Comments on Mixed Use Development, Including In-Fill Affordable Housing, Five Ways, Crows Nest

State Significant Development Application Number SSD-66826207

Figure 17 Construction vehicle routes

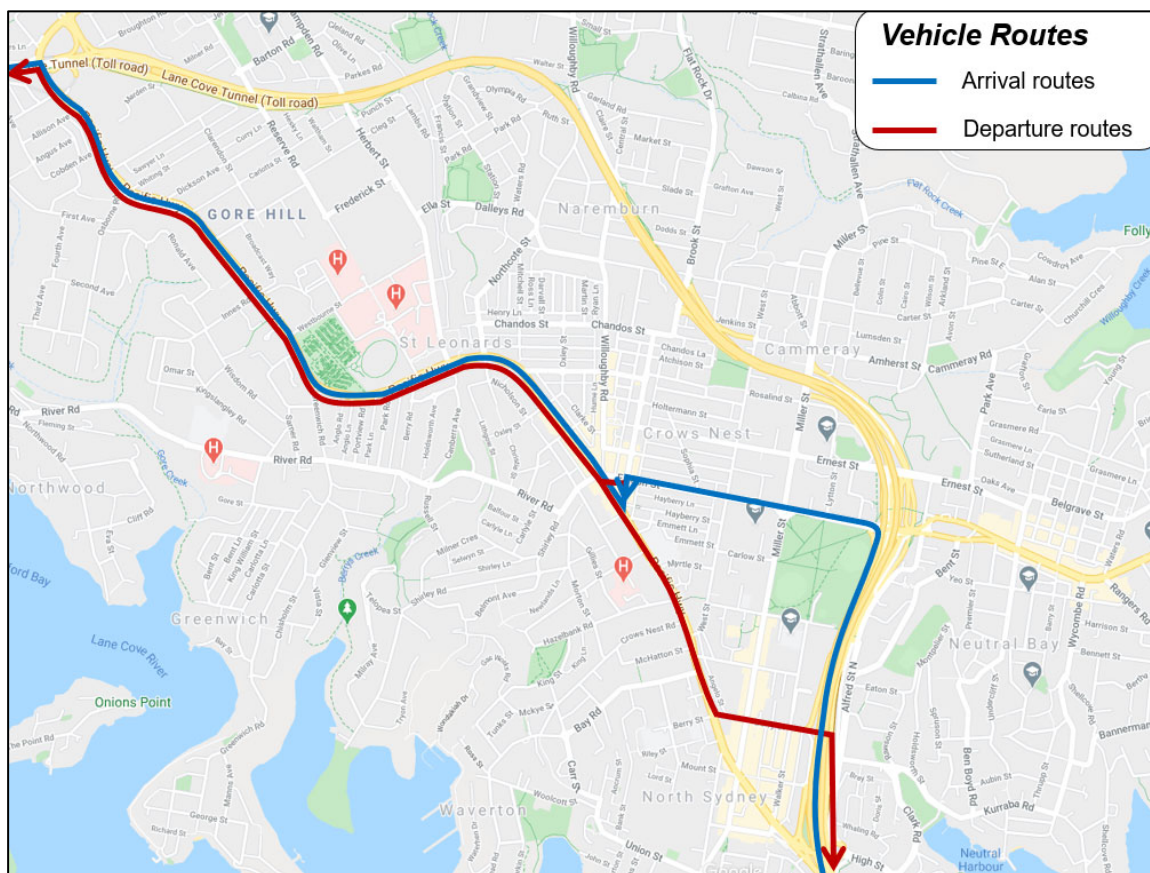
Of particular note is the analysis of “Construction vehicle routes” in the TIA paragraph 5.5:

1. The map in Figure 17 shows vehicles coming northbound on the Warringah Freeway leaving westbound at the Falcon Street exit and proceeding to turn left into Alexander Street. But:

- a. Due to changes related to the Warringah Freeway upgrade, this exit was closed some time ago and will not be re-opened. (It is to become an exit from the new Western Harbor tunnel.) Northbound traffic on Warringah Freeway will need to use the Miller Street exit. There is no right turn from Miller Street to Falcon Street, so the only options will be circuitous routes through the local streets.

- b. Even assuming the construction vehicles can get into Falcon Street and turn left at Alexander Street, they are now creating the deadlock situation described in item 3 above.

2. The map also shows vehicles southbound in Pacific Highway turning left into Alexander Street. This is an extremely tight turn. I have seen MRVs misjudge it and have to reverse back into the Pacific Highway traffic. It is a challenge for an MRV, but likely impossible for an HRV or AV.

3. The map also shows vehicles leaving the site turning left into Alexander Street and then into Falcon Street. For the reasons described above this will be almost impossible at some times for HRVs and AVs.

The TIA needs a complete rethink on construction vehicle access.

Figure 2 Proposed vehicle site access

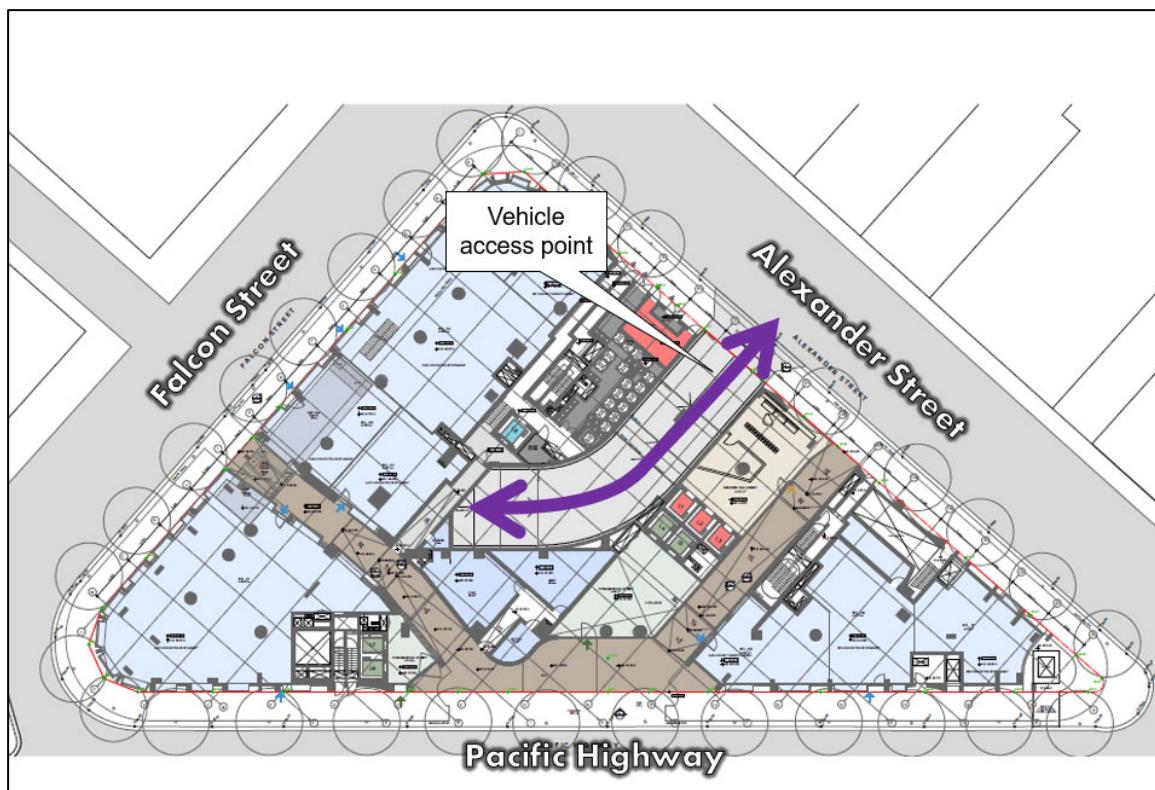
Overall, I think that putting driveway access to/from the site in Alexander Street will be totally unworkable. I appreciate that there are issues due to Pacific Highway being a State Classified Road (as acknowledged in the EIS paragraph 6.1.3.2) with high-use bus stops in the Falcon Street to Alexander Street block, but I think that putting the driveway there would at least have a chance of working.

The analysis in the TIA Appendix B appears to ignore any difficulties in leaving the site. For example, Section 2.4 has no consideration of the impact of vehicles banked up within the site waiting to leave. This makes the analysis of driveway traffic flow and loading dock use in the TIA difficult to accept.
